Reply To: address as below
Our Ref: 6/2018/2187/COND
Direct Tel: 01707 357211
Fax: 01707 357253
Email: planning@welhat.gov.uk

8 November 2018

RE: 6/2018/2187/COND – Submission of details pursuant to condition 3 (Material Samples) and condition 4 (Bicycle store) on planning application 6/2016/2339/FULL at 23 Park Street, Hatfield, AL9 5AT

13476-W-006-1st

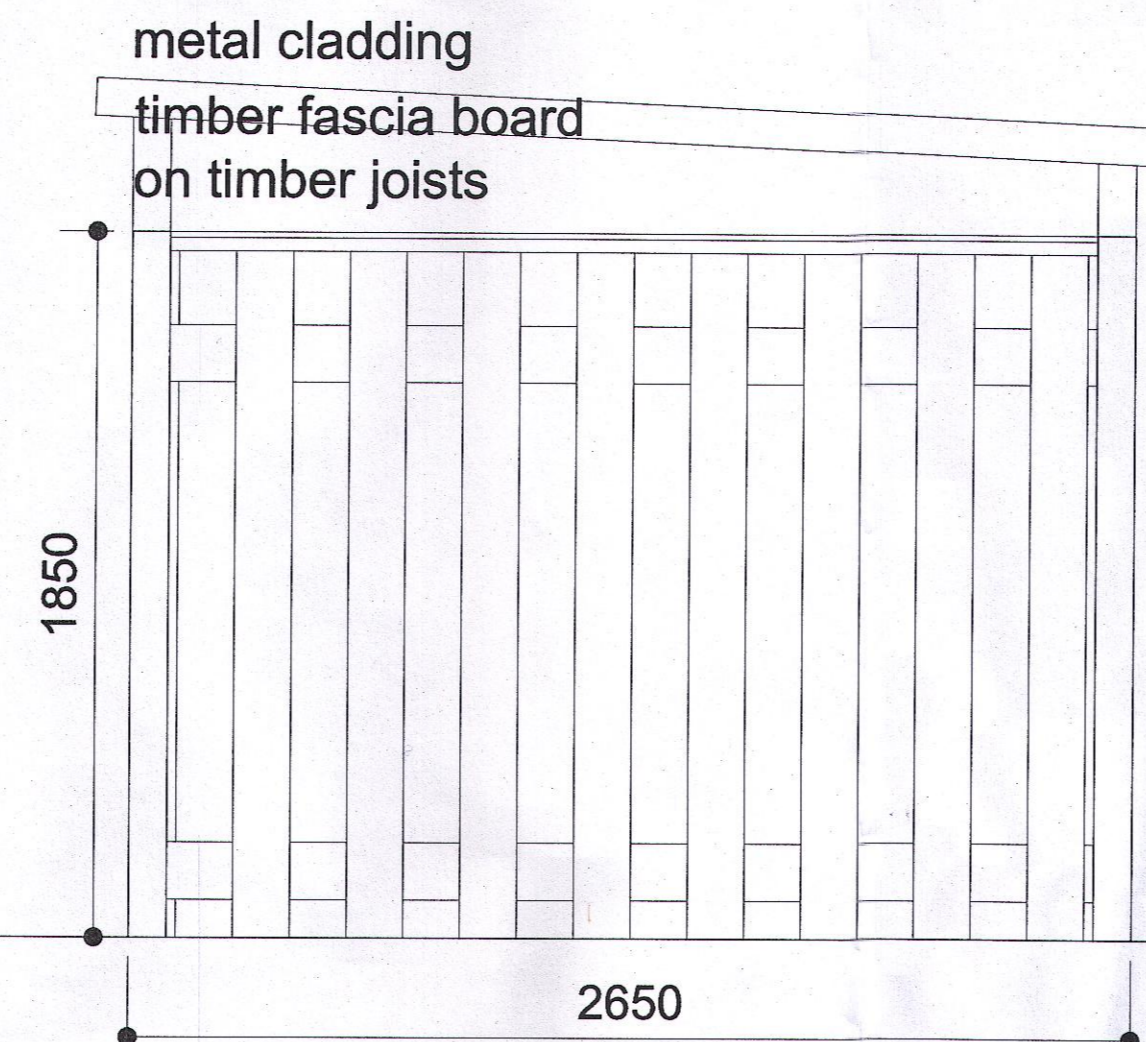
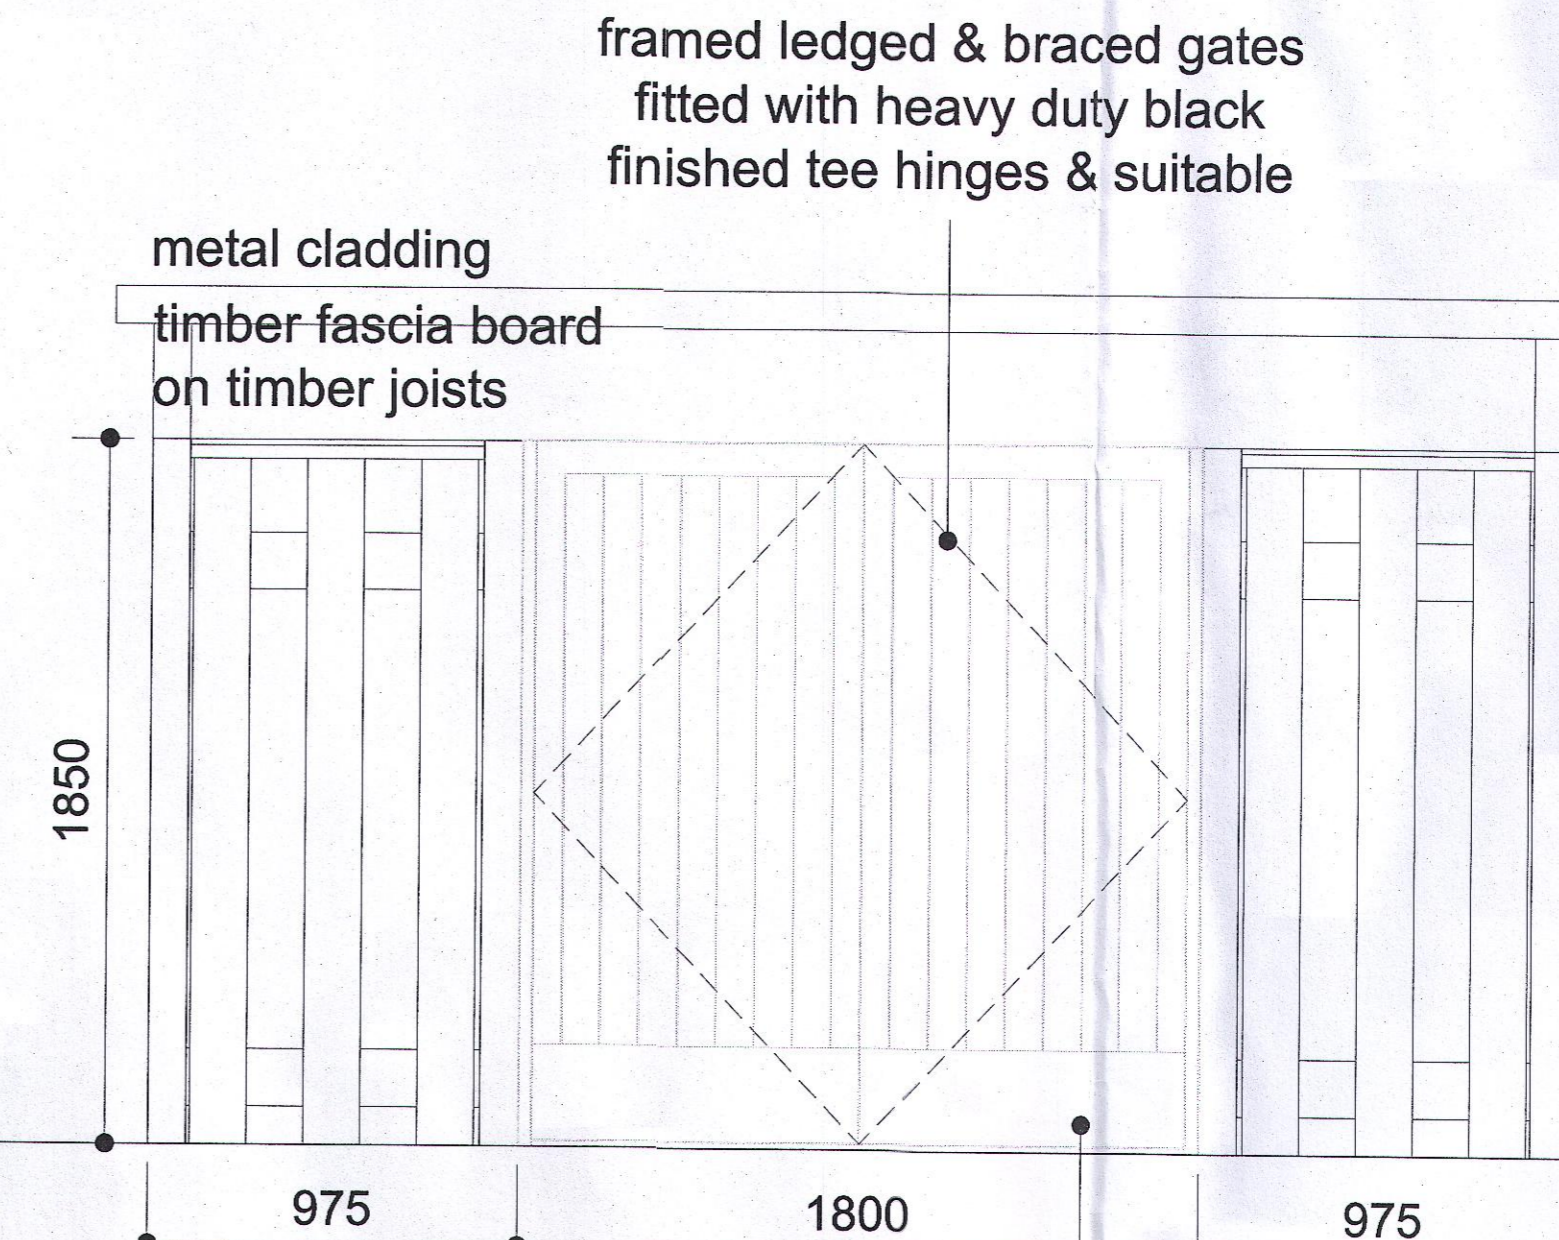
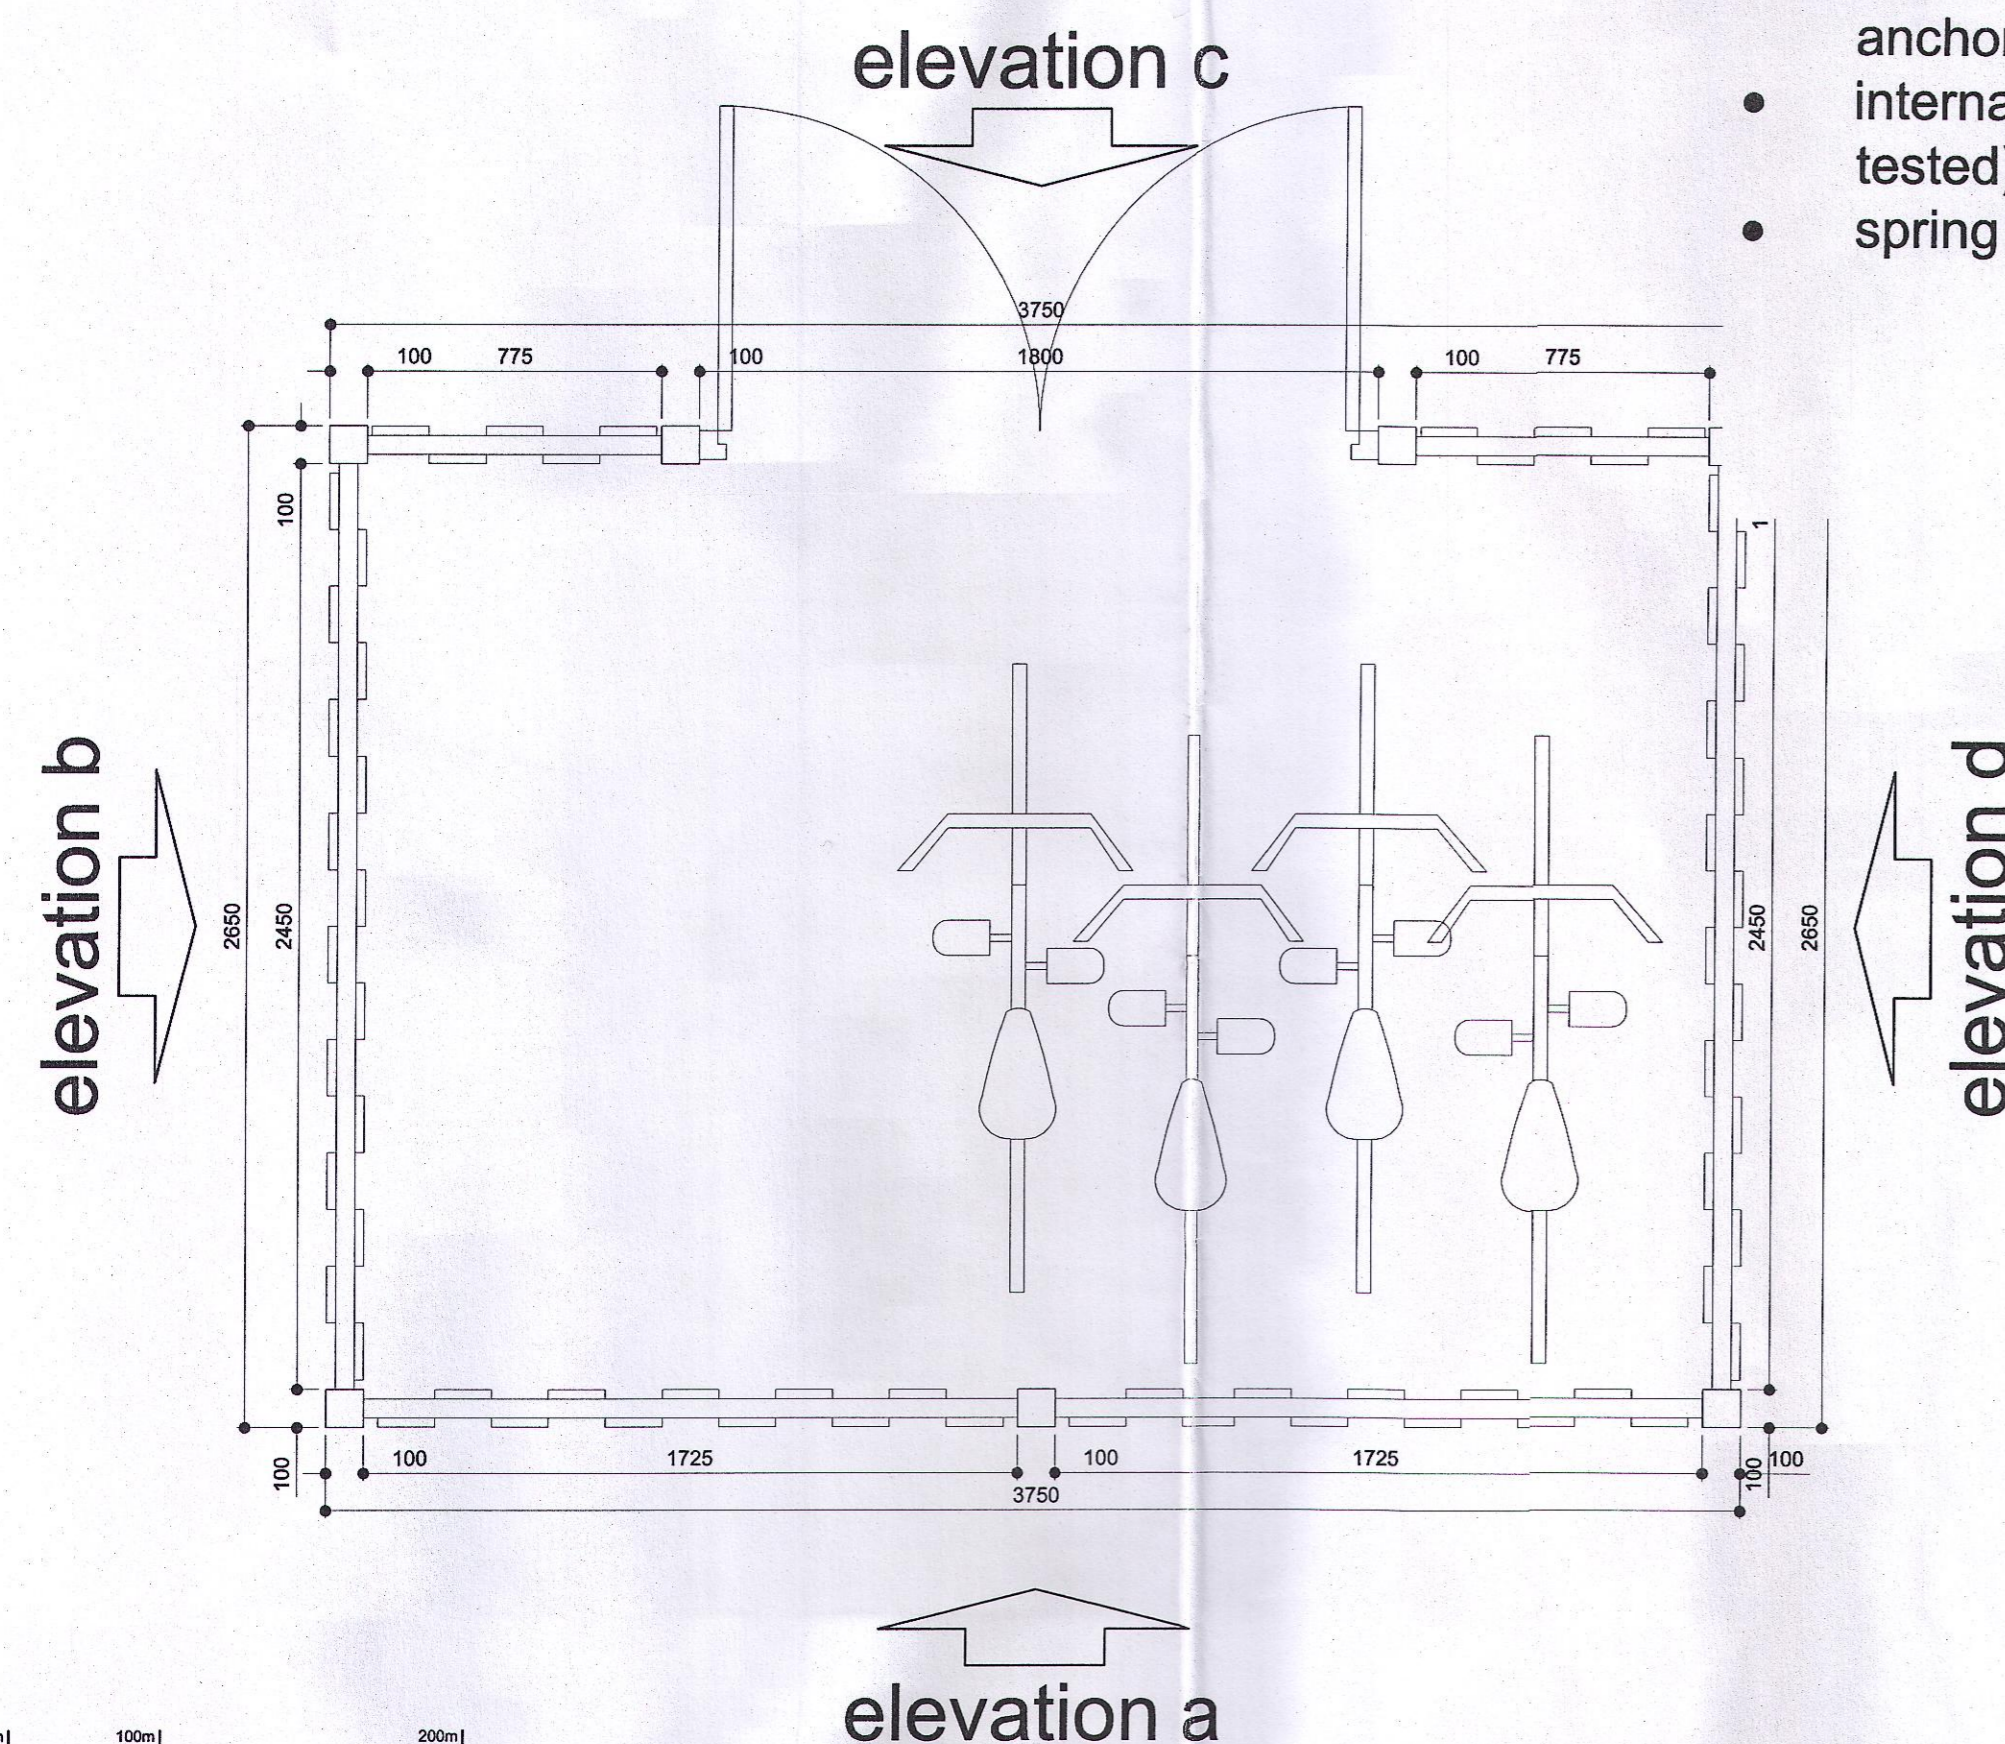
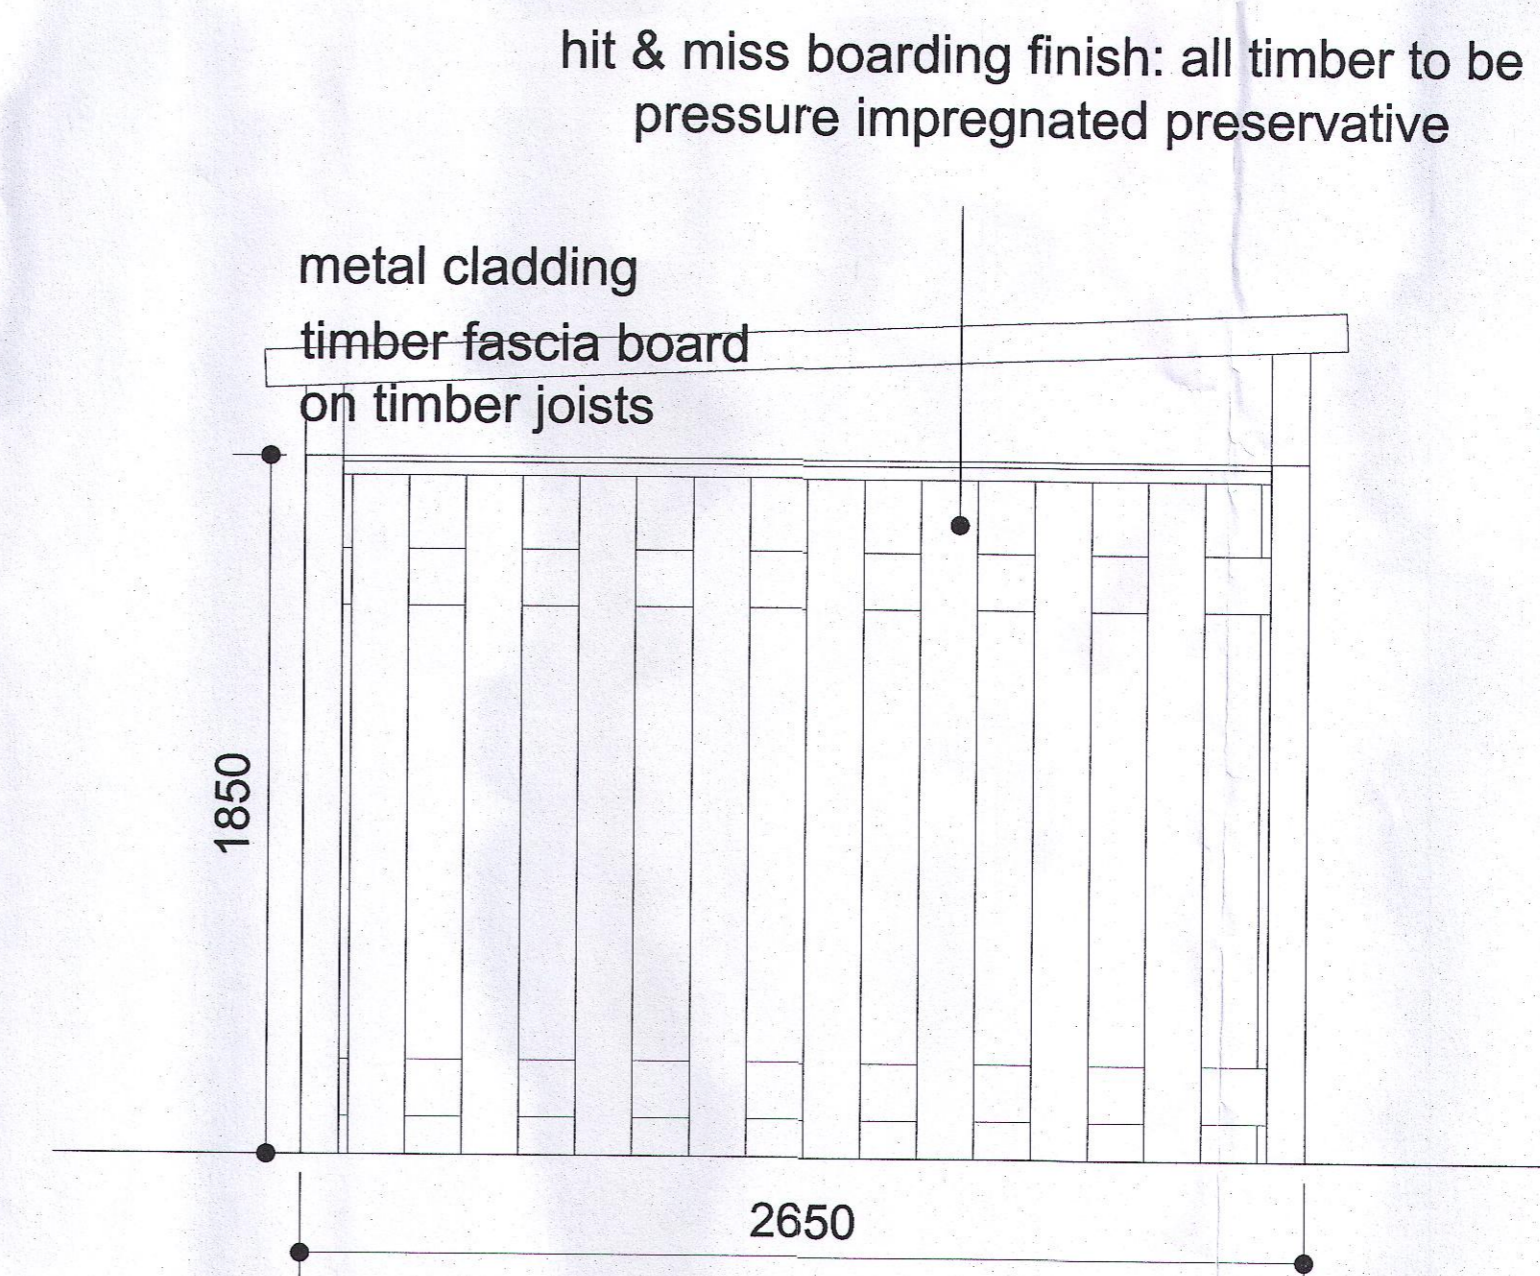
Drawing No 13476-W-001/RevC - Ground Floor Plan and site Layout
and
Drawing No 13476-W-006-1 – Cycle Store Details

I confirm that sufficient information has been submitted and the details are acceptable pursuant to condition 4.
